Recommendation Report for Planning Permission for Works or Extension to a Dwelling

REF NO: LU/148/15/HH

LOCATION: 20 North Street
Littlehampton

PROPOSAL: 1st floor rear extension. Resubmission of LU/31/15/HH. This application may be determined by Littlehampton Town Council under delegated powers

P.Robinson 01243 555208 E.Mail-peterrob@bt.com	
TITLE:-	Rear Extension @ 20 North street Littlehampton West Sussex BN17 6JJ
DATE:-	23rd January 2014
SCALE:-	Plans & Elevations 1-100 Block Plan 1-500
DRAWN:-	P.Robinson
DWG. No. 150122/1C

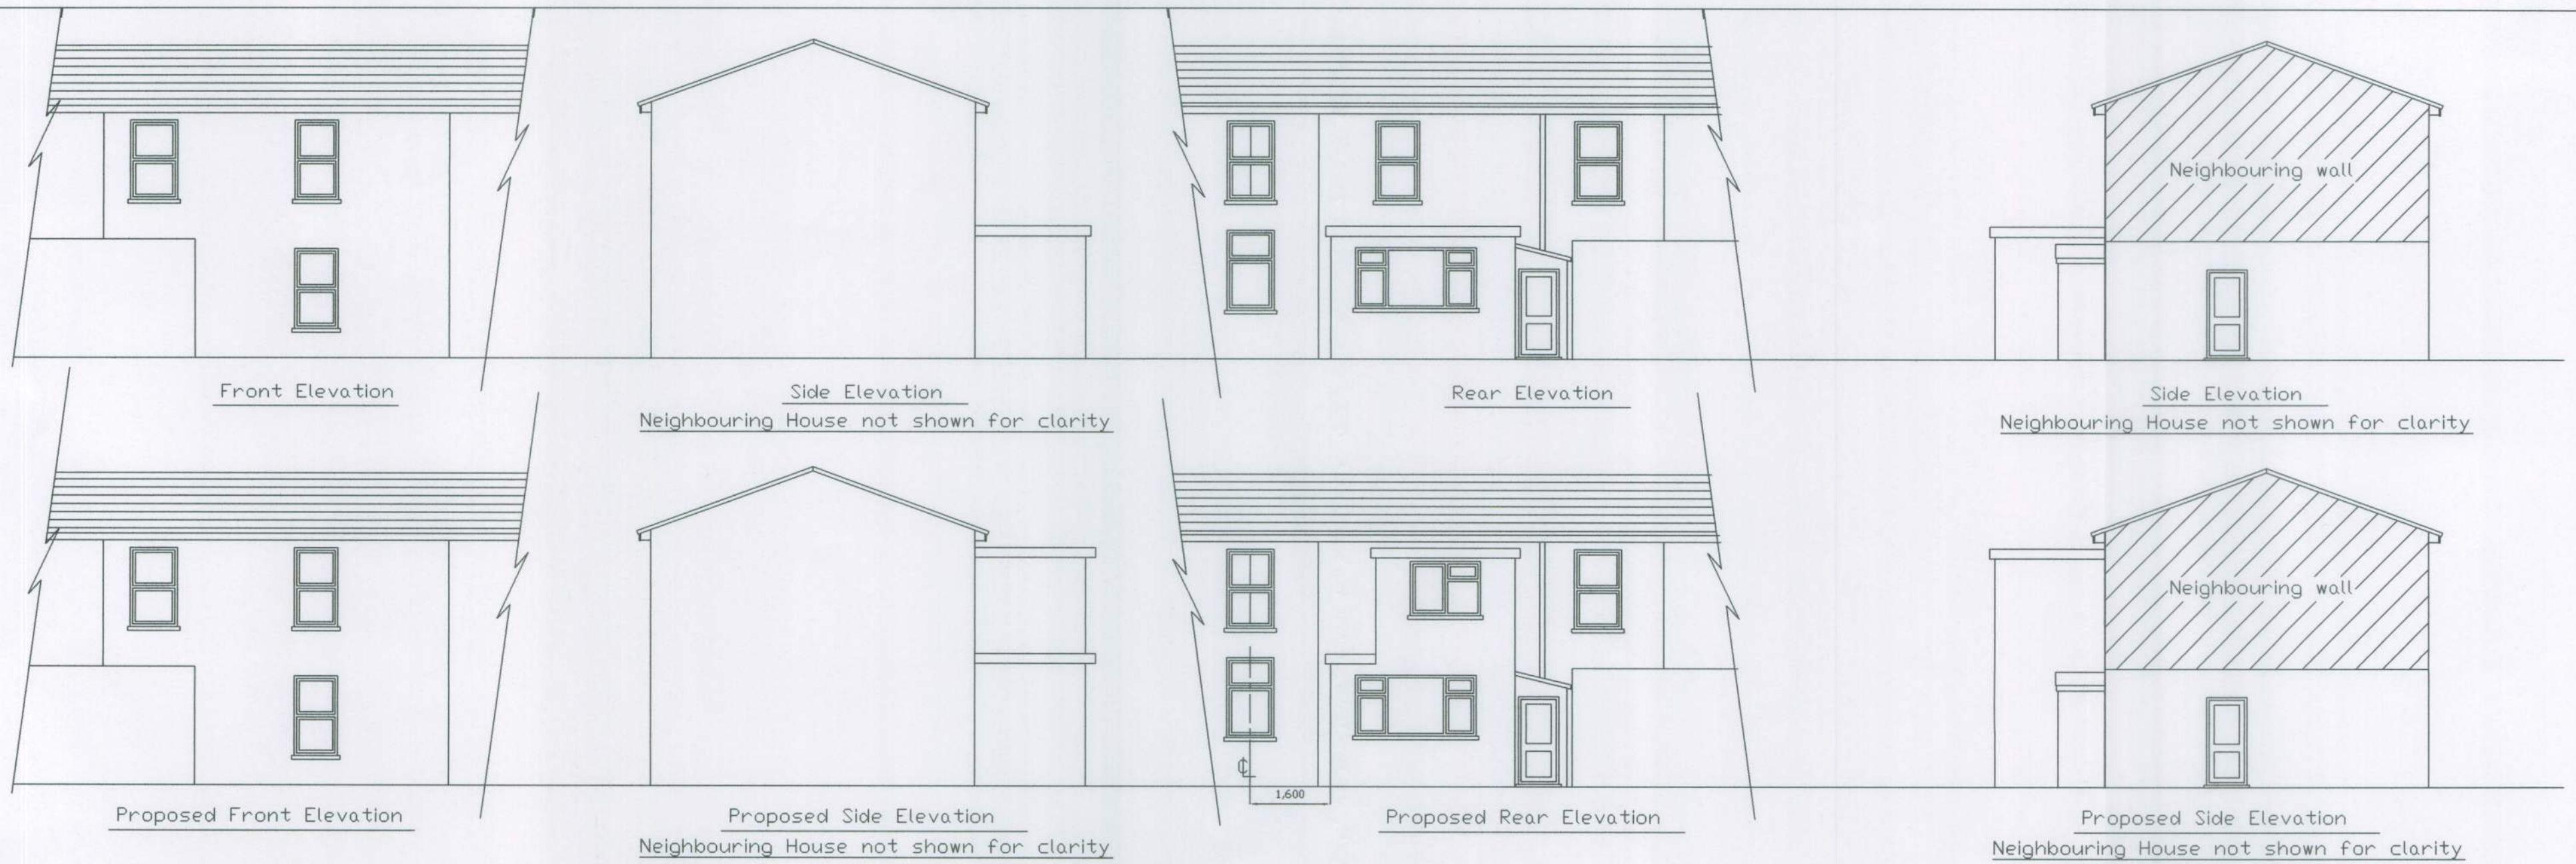
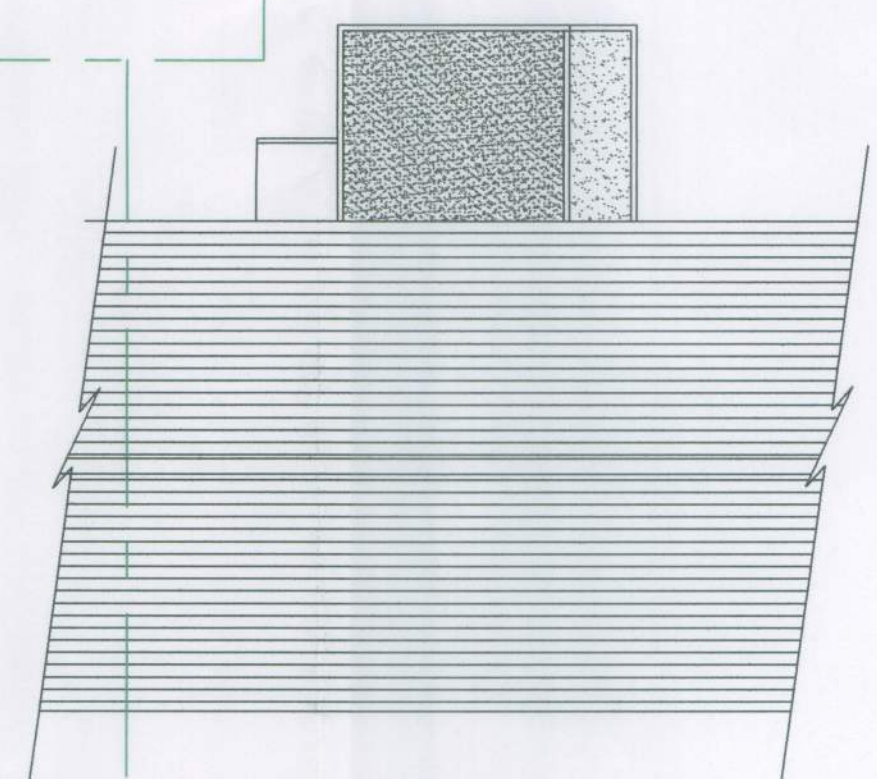
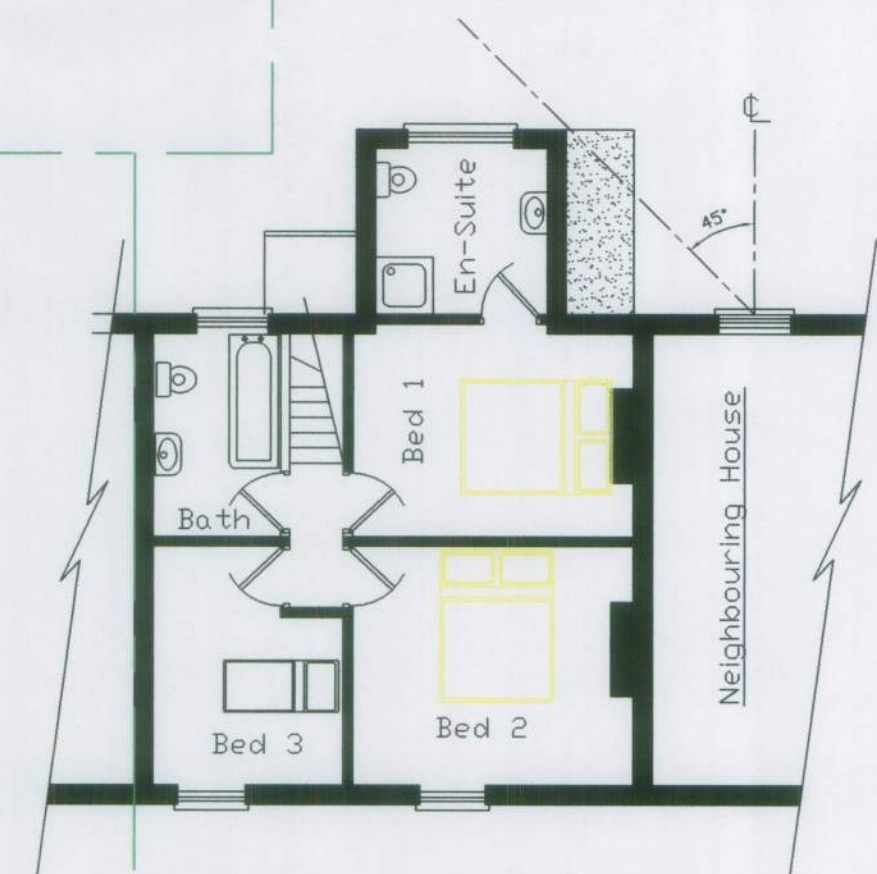
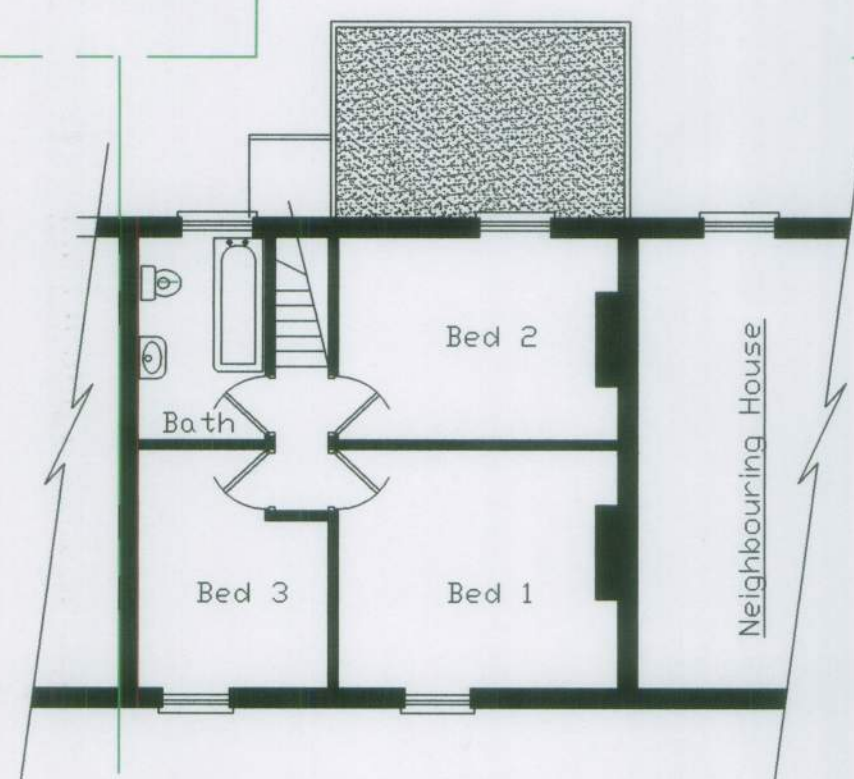
The application follows a refused application LU/31/15/HH which was for a wider first floor extension which was 0.8m from the boundary and did not comply with the 45 degree rule. The depth and height of the extension remain unaltered.

The extension would be constructed on top of a single storey extension which has been constructed under permitted development rights. The two storey extension is 1m from the western boundary with No. 18 and this adjoining property has a single storey extension set approximately 1m from the boundary. This separation distance to the boundary when considered with the height of the extension at approximately 4.4m to eaves is judged to have an acceptable impact on the neighbouring property and garden. The neighbouring property has a bedroom window at first floor and a ground floor window in the rear extension facing the extension and a window at ground floor in the rear elevation which would lose light.

The Council has adopted the 45 degree rule as a tool to balance the interest of those persons wishing to extend their premises and their neighbours by ensuring that extensions do not seriously affect a neighbour's outlook or daylight. The agent has submitted plans to demonstrate that the rear projection of the proposed extension combined with the proximity to the boundary means that the extension would comply with the Council's adopted 45 degree rule. The extension would not result in a materially adverse overbearing effect on the garden or rear elevation of No. 18. There are no windows in the side elevation of the proposed extension so no direct adverse overlooking would result.
